**[FWD: first response from Portland building inspection]**

Subject: 89 Pleasant Ave., PI, BP#2017-01190 plan review comments

I am in review of this permit for building code compliance and have some comments for you to address in order to continue with this review. Please provide information for the following items:

FIRST FLOOR

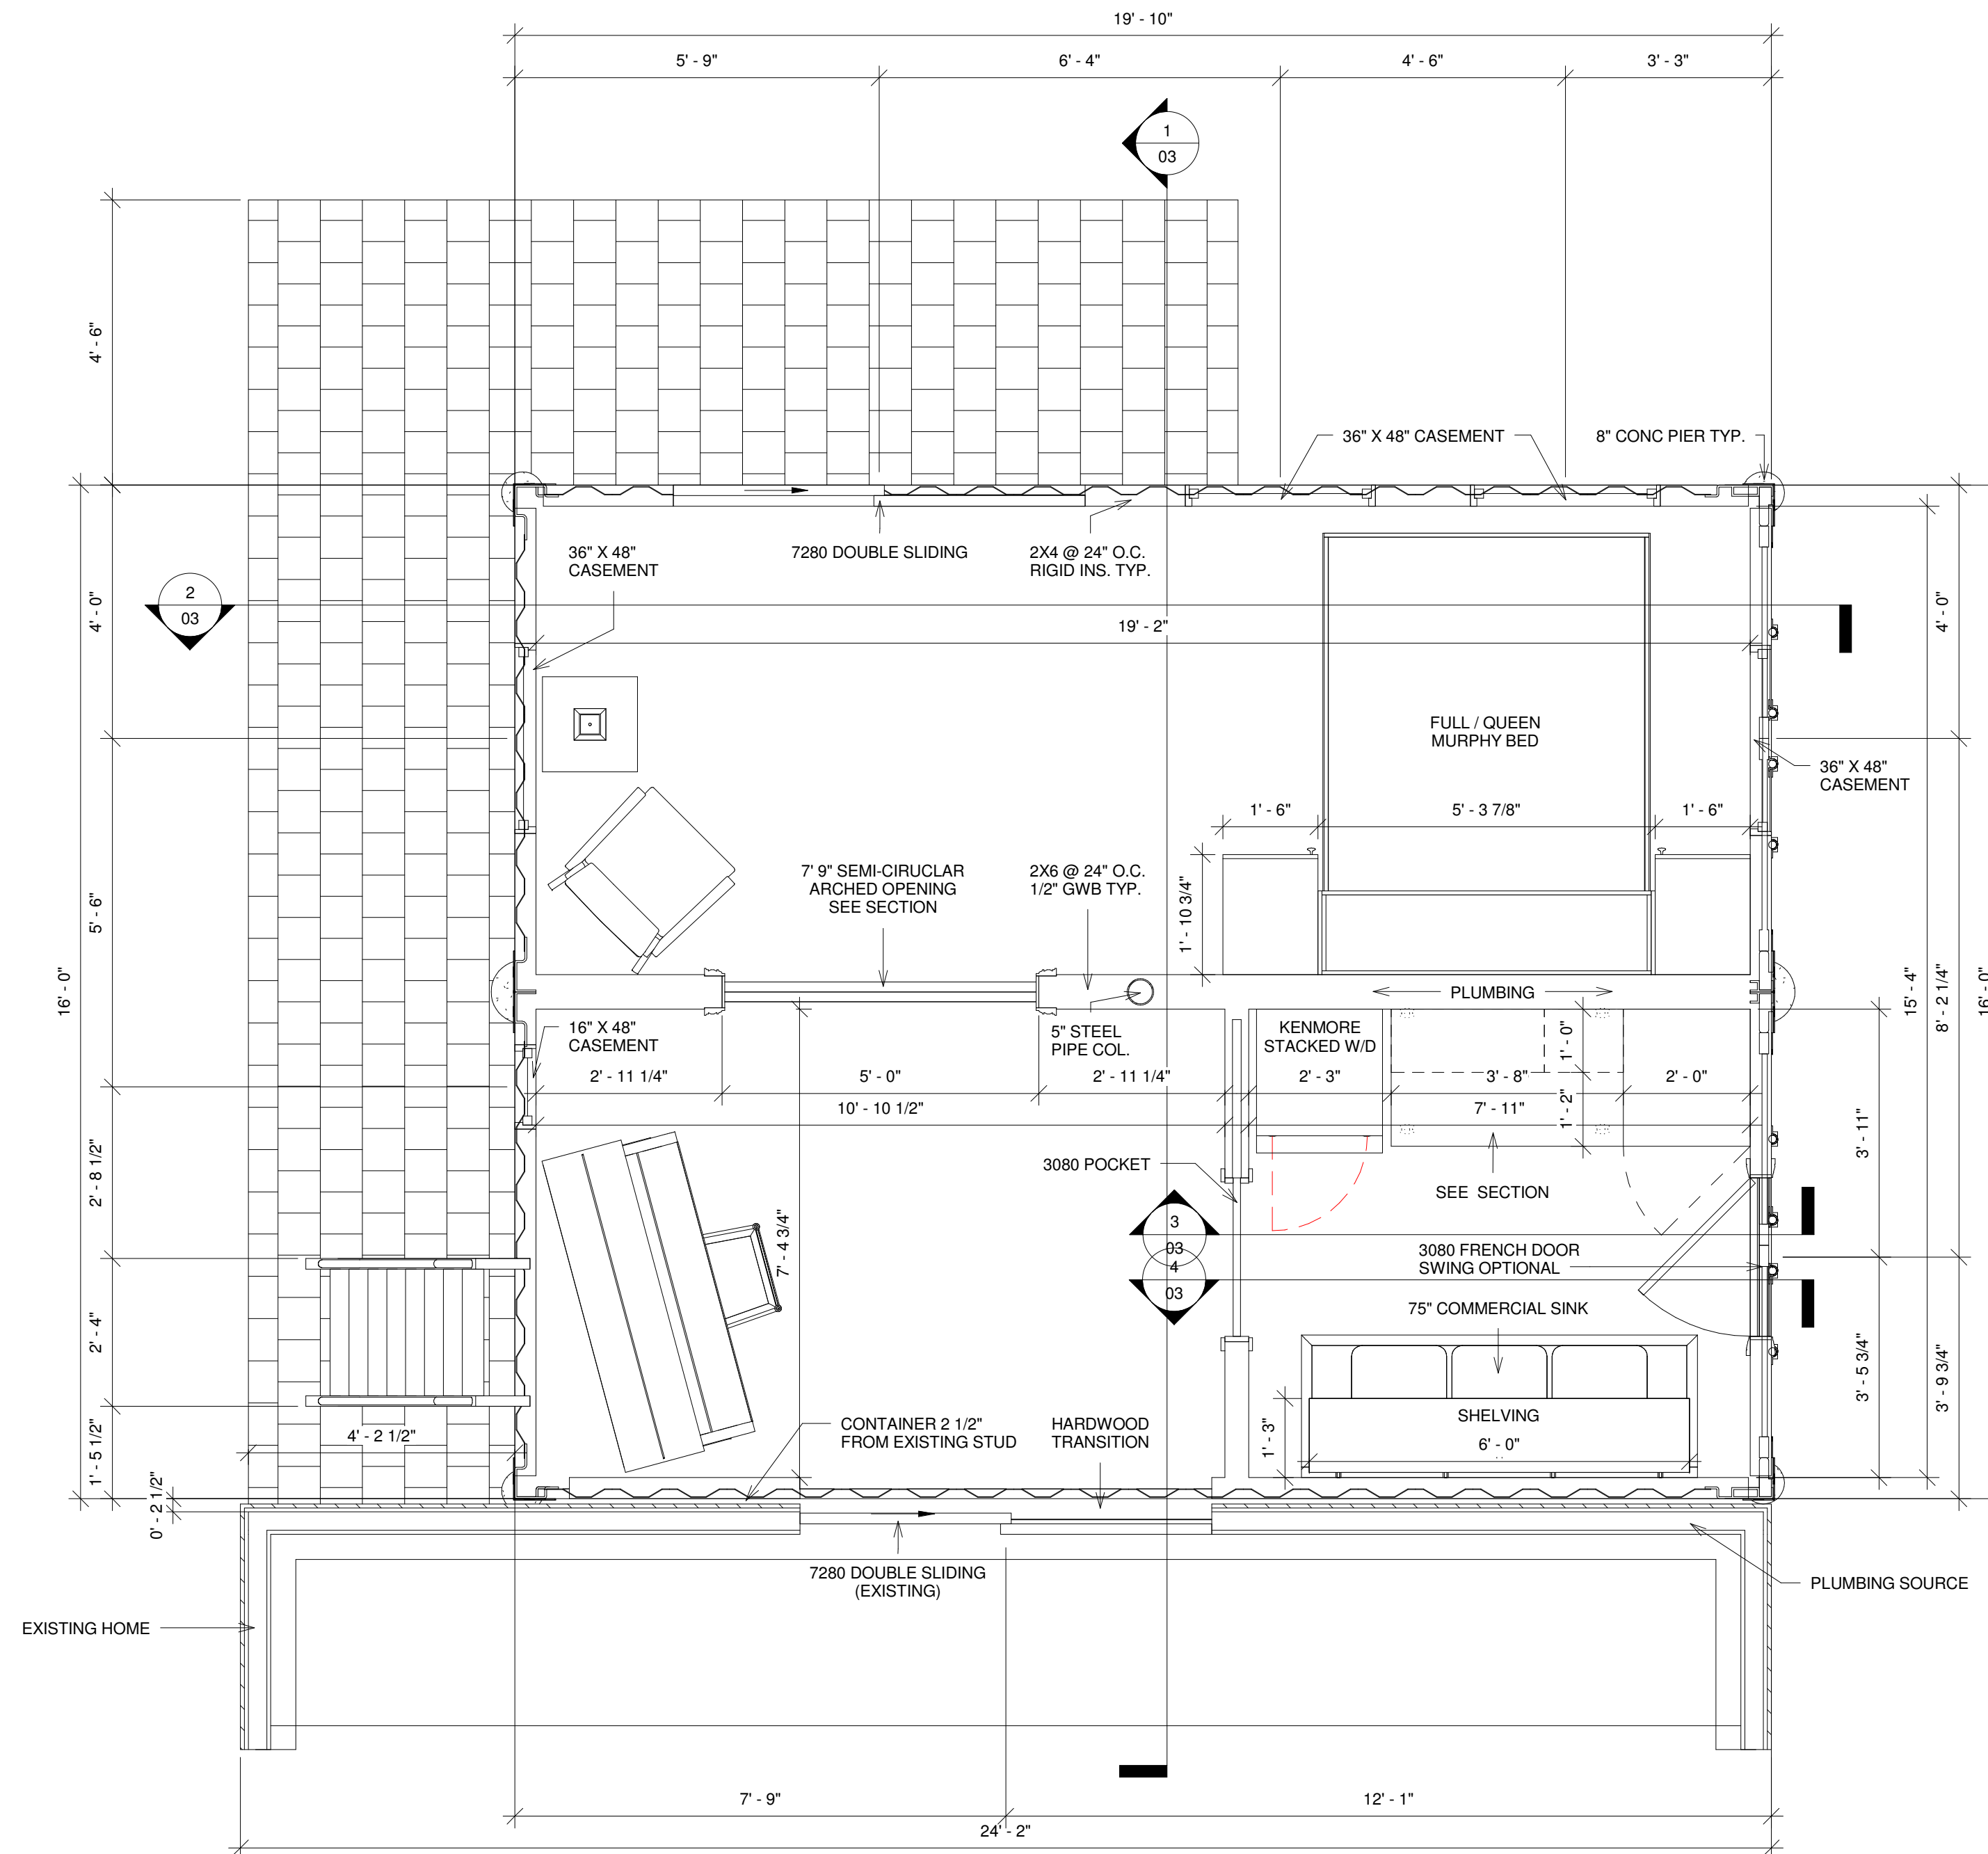
4. Attachment and anchoring details of the addition to the foundation are required, as well as these details for the rooftop deck materials and guardrails. The height of the guardrail is not compliant at less than 36" and opening dimensions are required.

5. Egress from habitable levels shall be by a ramp or stairway per IRC Sec. 311.7, a ships ladder is not an approved means.

S1

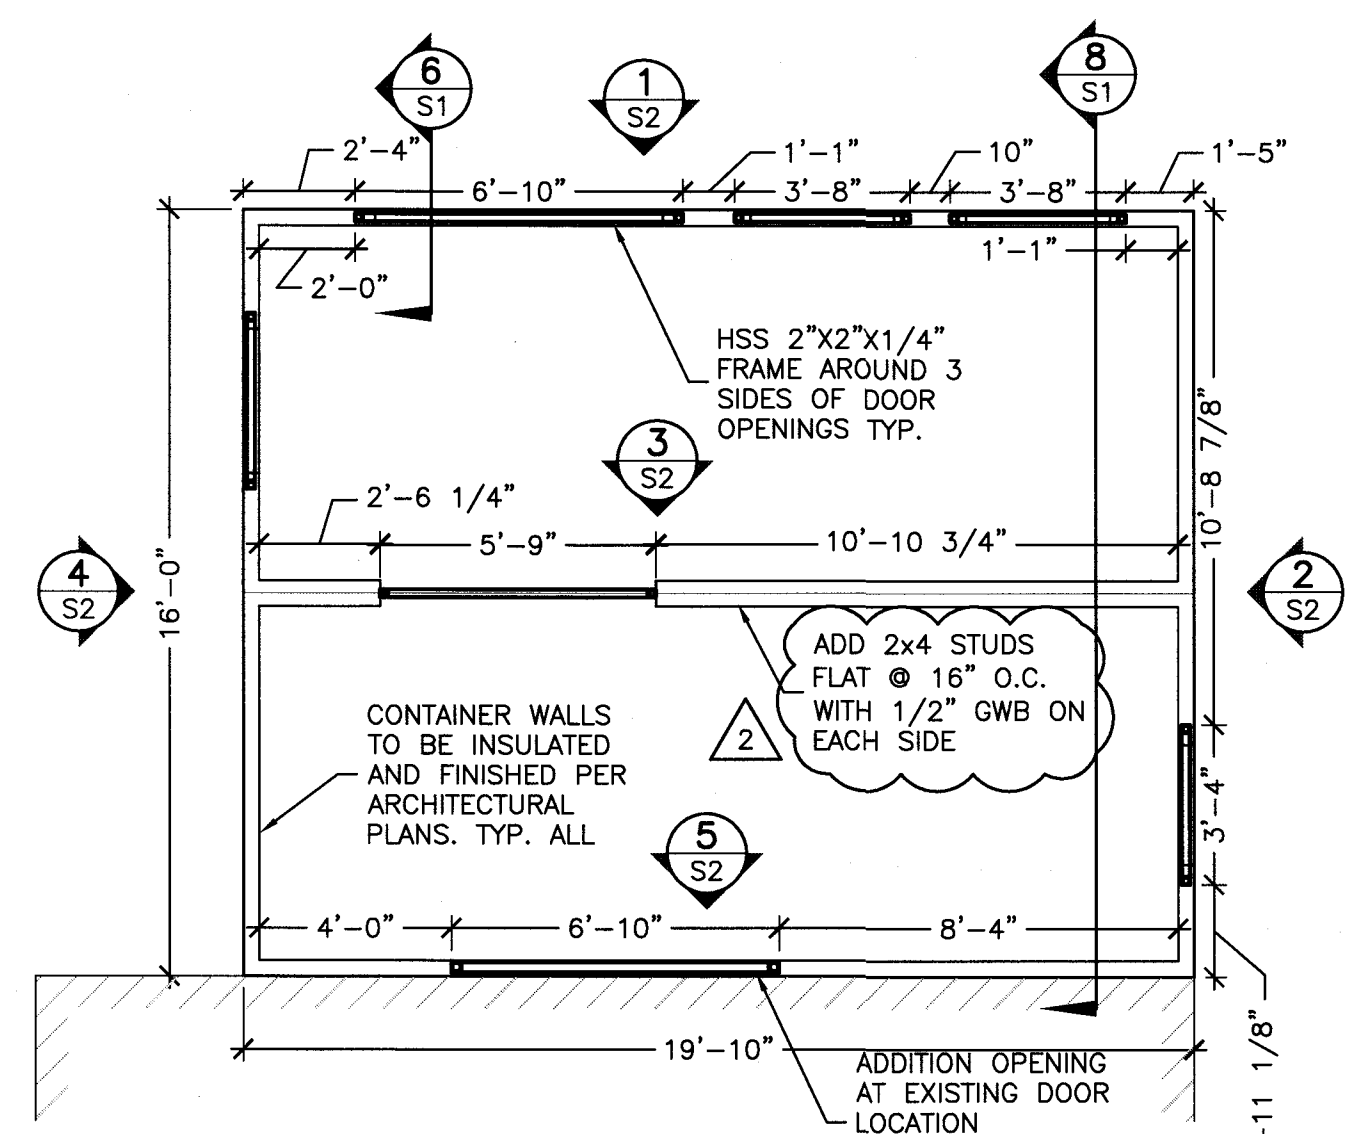
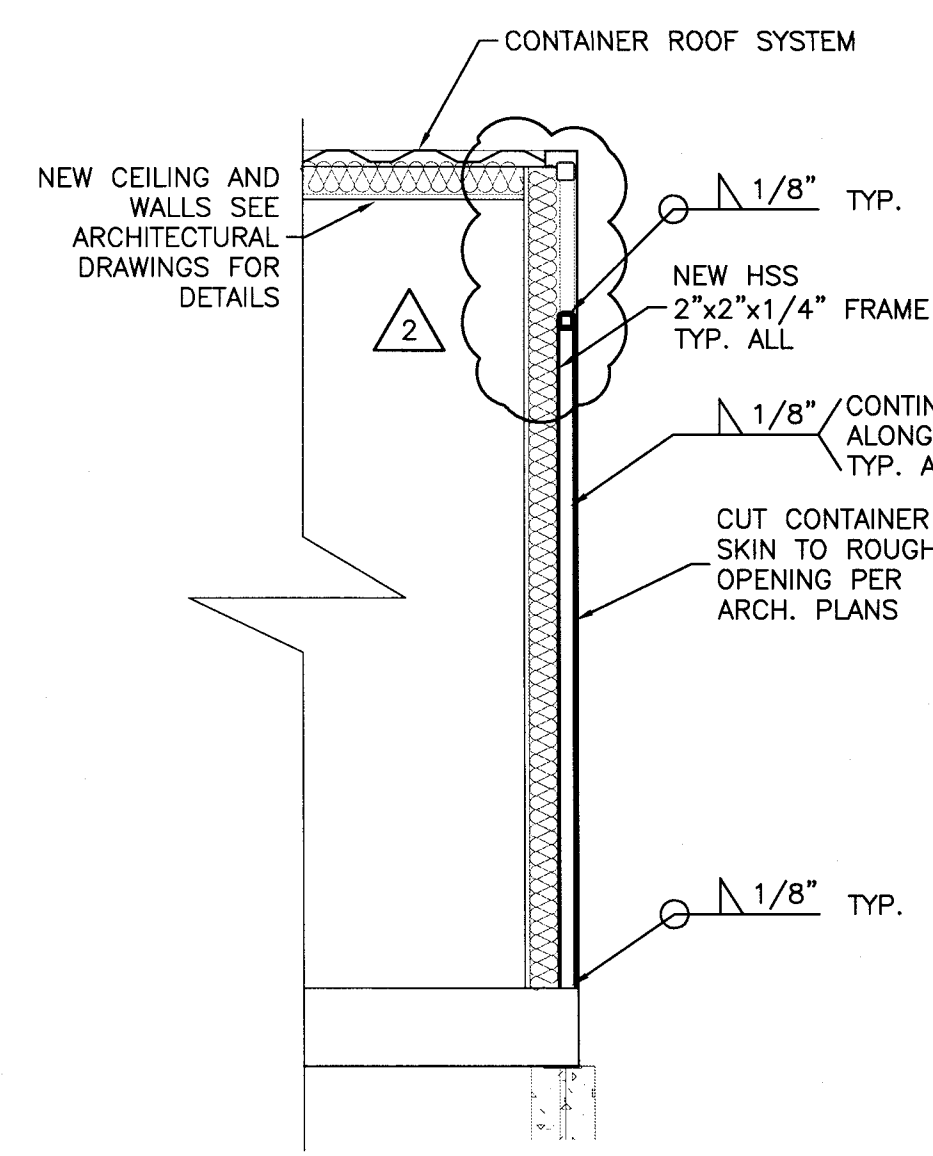
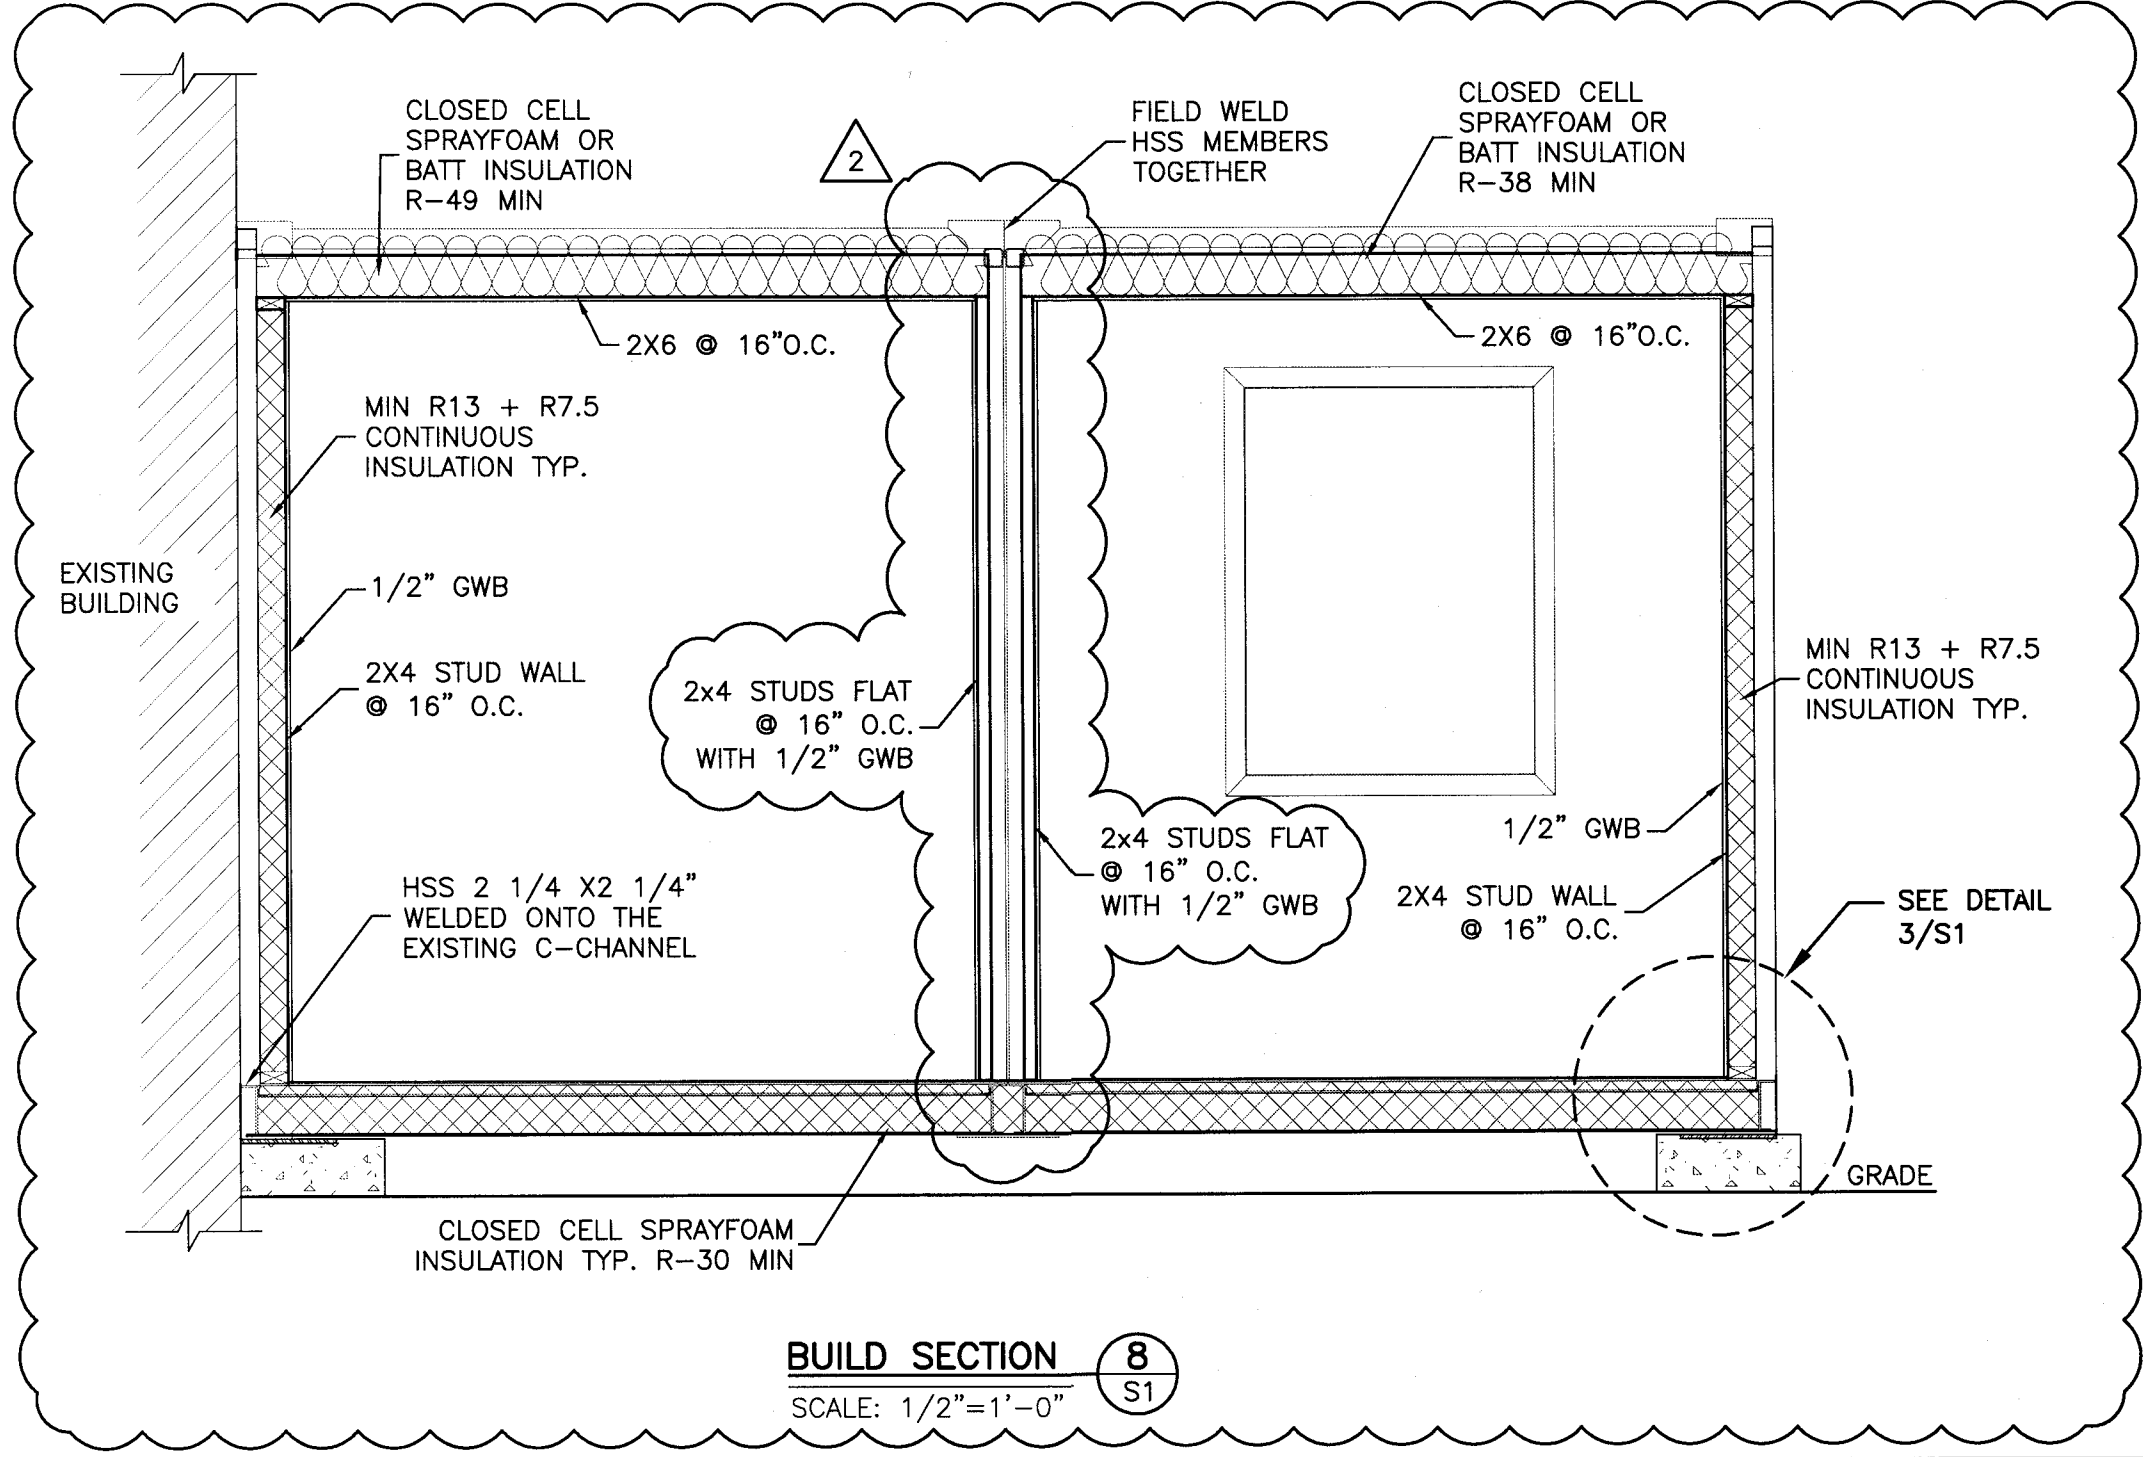
3. Storage shipping containers that are modified to be occupied as habitable structures are not recognized in the code. These are not constructed per conventional standards and practices, therefore, all modifications shall be reviewed and designed by a structural engineer per the prescribed loads, including parameters for the condition of the container.
